RFI Item 9 – Tree Survey

Sand and Gravel Extraction, Knockroe, Bandon, Co. Cork
(Plan. Ref. 25/04666)

Keohane Readymix Ltd.

254666-04/12/2025-FI Tree Survey

Tree Survey Map

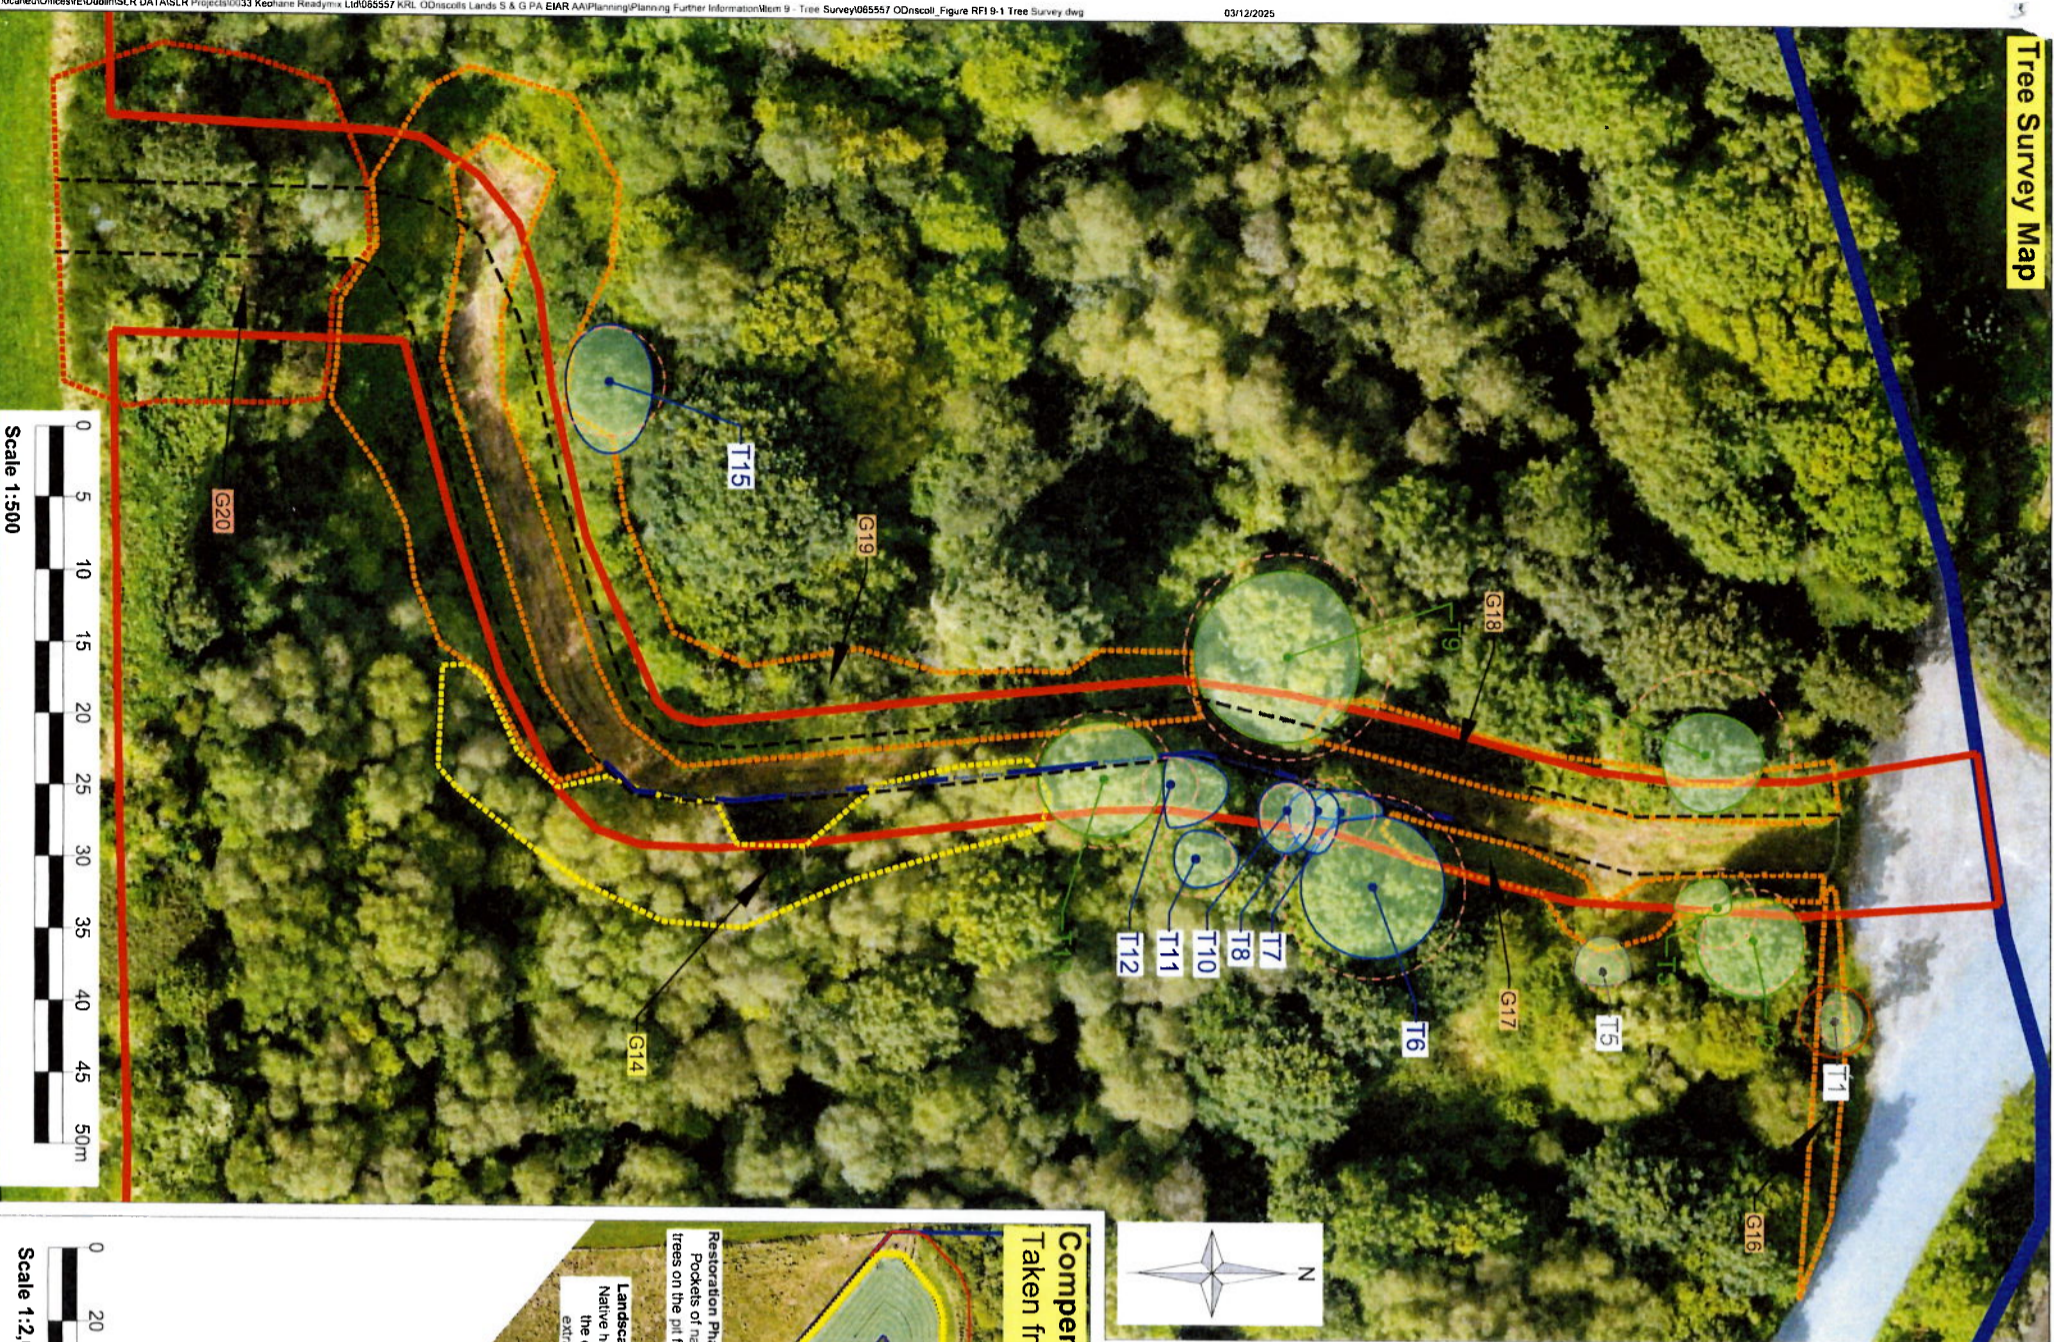
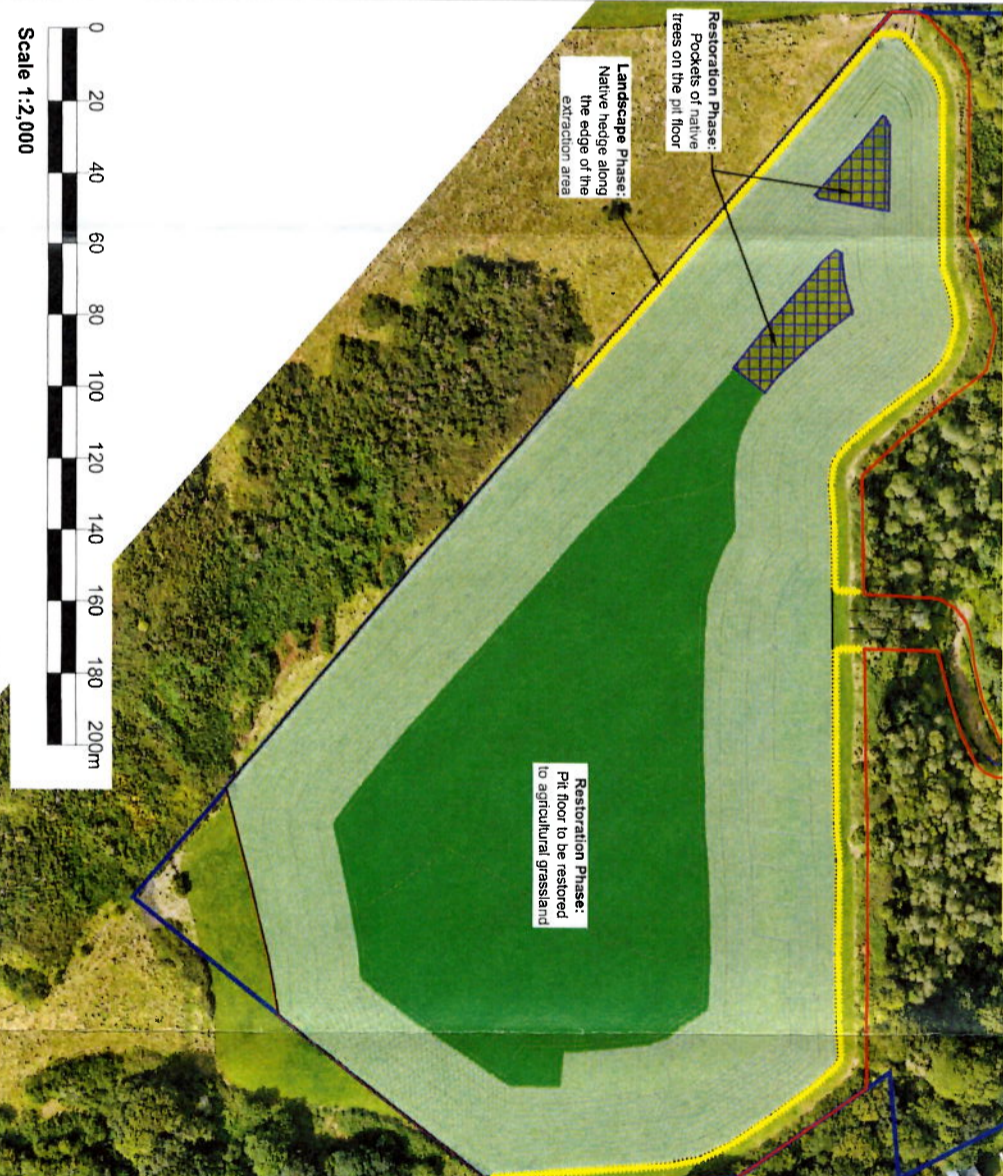
“Please submit a tree survey, conducted by an arboriculture expert, for the site which shall include the following details:

- a. Identify the age, species, and condition of all trees within the site.*
- b. A site layout plan, identifying all the trees on the site.*
- c. Identify which trees are required to be removed to facilitate the development.*
- d. The tree protection measures which will be implemented on the site to protect the trees for retention.*
- e. Details of compensatory planting on the site to ensure that there is no net loss of biodiversity on the site.”*

The response to the individual items requested as part of RFI Item 9 is provided in the following sections, as well as on **Figure RFI 9-1 – Tree Survey and Compensatory Planting Plan**, enclosed with this report.

It is intended to retain all of the individually recorded trees along the access track, i.e. **T2-T14** and **T15**, as well as **G14**. Some of these trees are located along the edge or in close proximity of the existing access track and parts of their root protection areas (RPA) are located along the access track. However, no major branches overhang the track and only limited removal of small branches would be required to clear the route for the vehicles accessing the proposed sand and gravel pit.

- T1:** This tree needs to be removed to facilitate the sight lines to the east of the site entrance.
- G16:** This group needs to be fully removed to facilitate the sight lines to the east of the site entrance; note this comprises scrub species only.
- G17-19:** These groups need to be partially removed to facilitate the widening of the existing access track; note these comprise mostly scrub species, such as gorse and bramble and only young tree specimen.
- G20:** This group needs to be partially removed to facilitate the access ramp into the proposed extraction area.

There are a number of trees in close proximity to the eastern edge of the existing access track (i.e. **T7-8**, **T10**, **T12-13** & **G14**). In order to protect the stems of these trees from damage from passing vehicles, it is proposed to erect a sturdy post & rail or post & wire fence, 1 m from the edge of the existing access track. In this location the track will be widened largely in a western direction, were only scrub and young trees will be affected by the works (i.e. **G18-19**). The approximate location of this fencing is indicated on **Figure RFI 9-1**.

This planting was detailed on **EIAR Figure 2-5** (Landscape and Restoration Plan), which formed part of the EIAR submitted with the planning application. This is replicated on **Figure RFI 9-1** enclosed with this report.

The proposed planting consists of 660 m of a diverse native hedgerow surrounding parts of the proposed extraction area, to be planted on commencement of the development. It further comprises 800 m² of a diverse native tree mix in two pockets on the pit floor, when the extraction works are completed.
